From: Anita Gardner
Sent: 09 May 2013 11:03
To: [REDACTED]
Subject: LU/82/13/L 5 River Road, Littlehampton

5 River Road, Littlehampton - Alterations to Listed Building.

DRAWING No.
1063/P/1

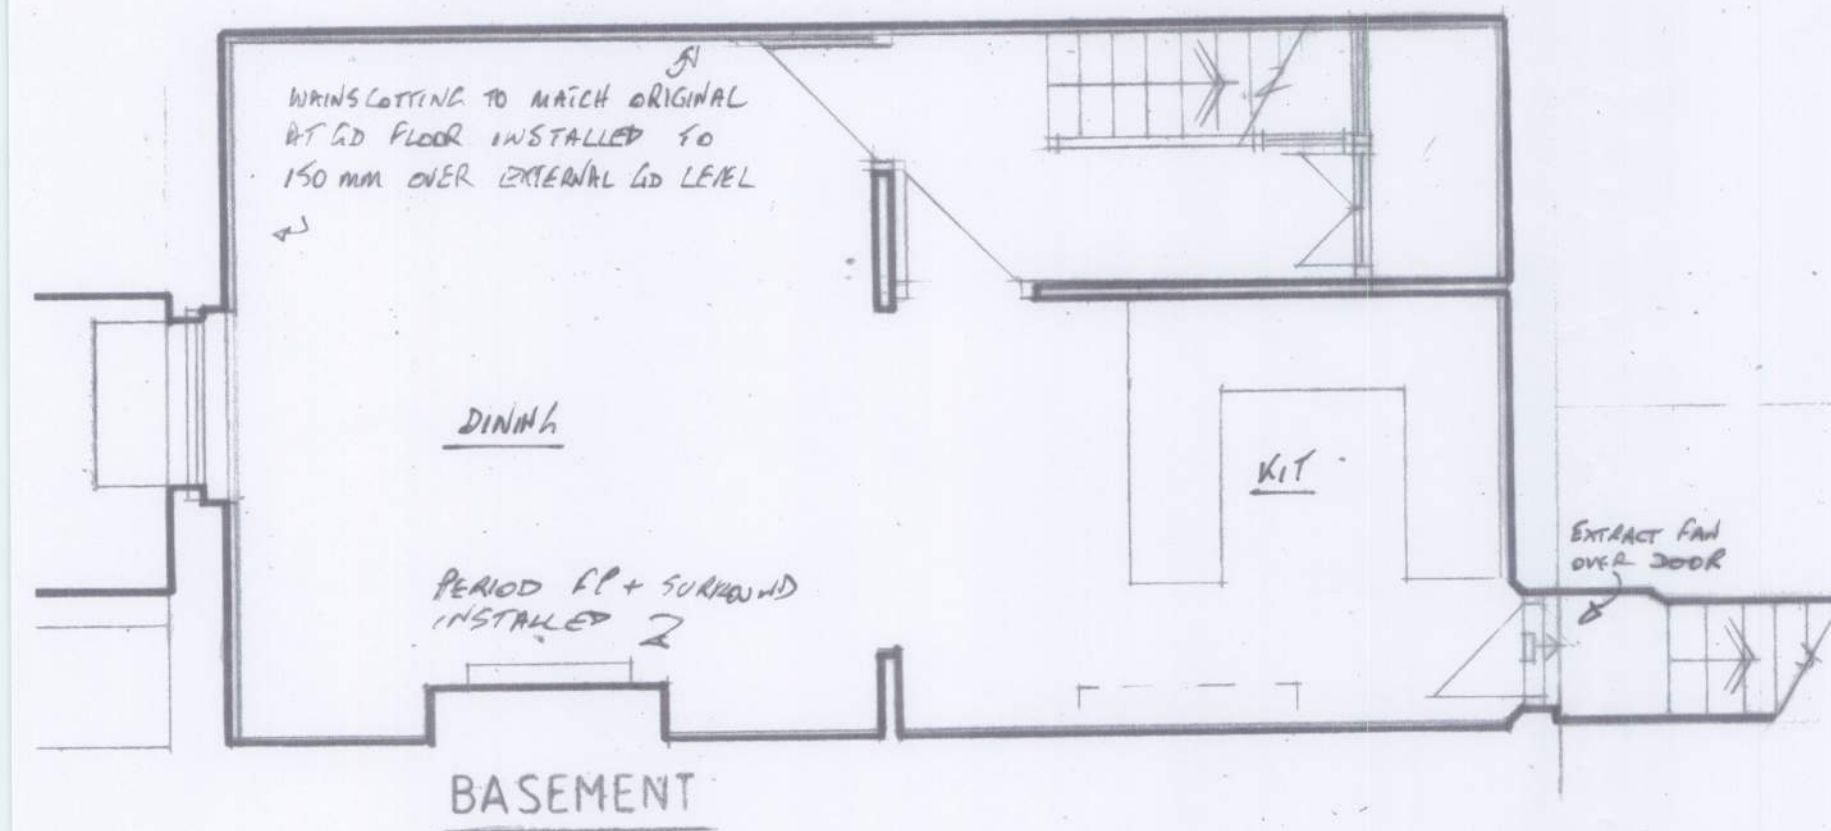
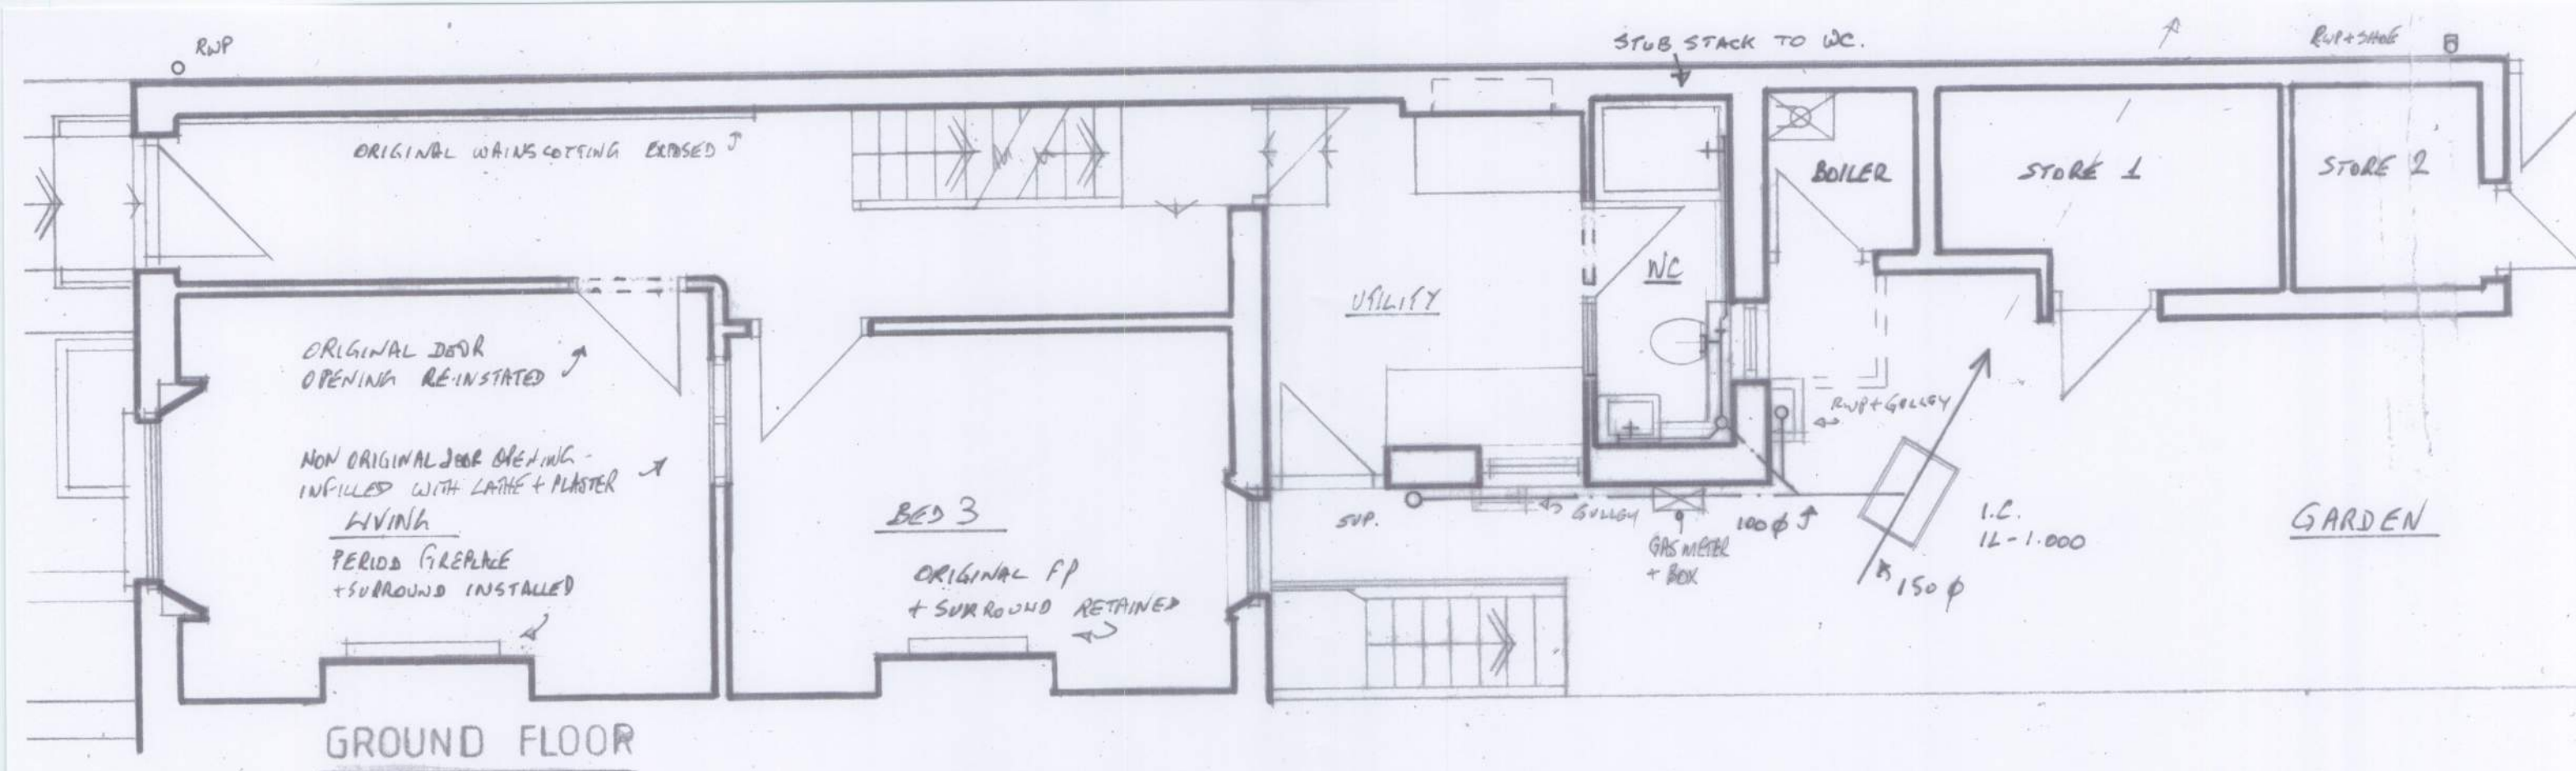
I have discussed your proposal with Mr Scamans, the Building Control Officer for the area and he has concerns that if, as proposed, the basement area is used for habitable accommodation it will need to be compliant with Building Regulations from a fire/damp perspective. I note that the submitted listed building consent application makes no reference to treatment of this area, other than the floor plans showing use as a dining/kitchen area and I would therefore appreciate confirmation of your clients intentions in this respect.
